From: Daun Johnson on behalf of Planning.Responses
Sent: 24 June 2026 08:06
To: Planning Scanning
Subject: FW: Arun Conservation Area Advisory Panel comments on applications

From: Brian Banister [REDACTED]
Sent: 23 June 2026 16:56
To: Planning.Responses <Planning.Responses@arun.gov.uk>
Subject: Arun Conservation Area Advisory Panel comments on applications

Hello,
Thankyou very much for the consultations. The **Arun Conservation Area Advisory Panel** wish the following comments to be taken into consideration in the determination of the applications:

SITE, BLOCK & LOCATION PLAN

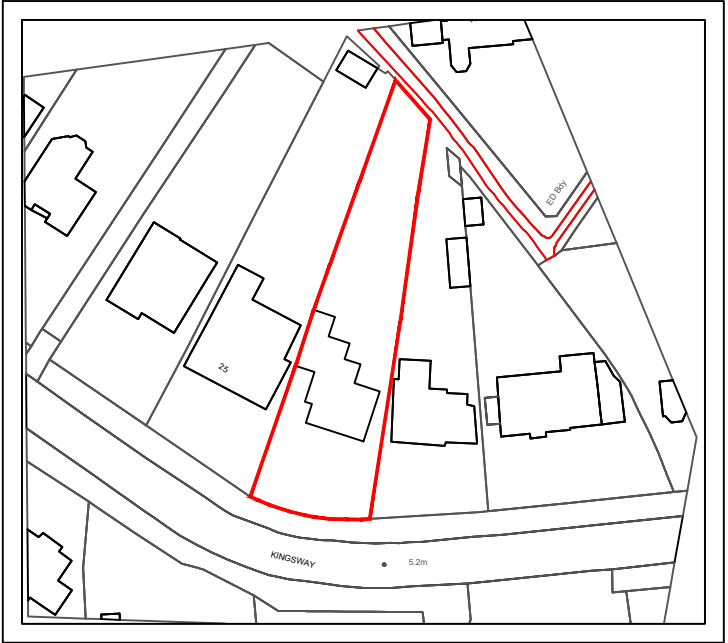
There appear to be other premises with front boundary fencing of similar height. The extent of such fences is limited and does not yet unduly impact on the general feeling of openness on the estate.

The Panel would have preferred the use of appropriate boundary planting rather than solid fencing, or a combination of both.
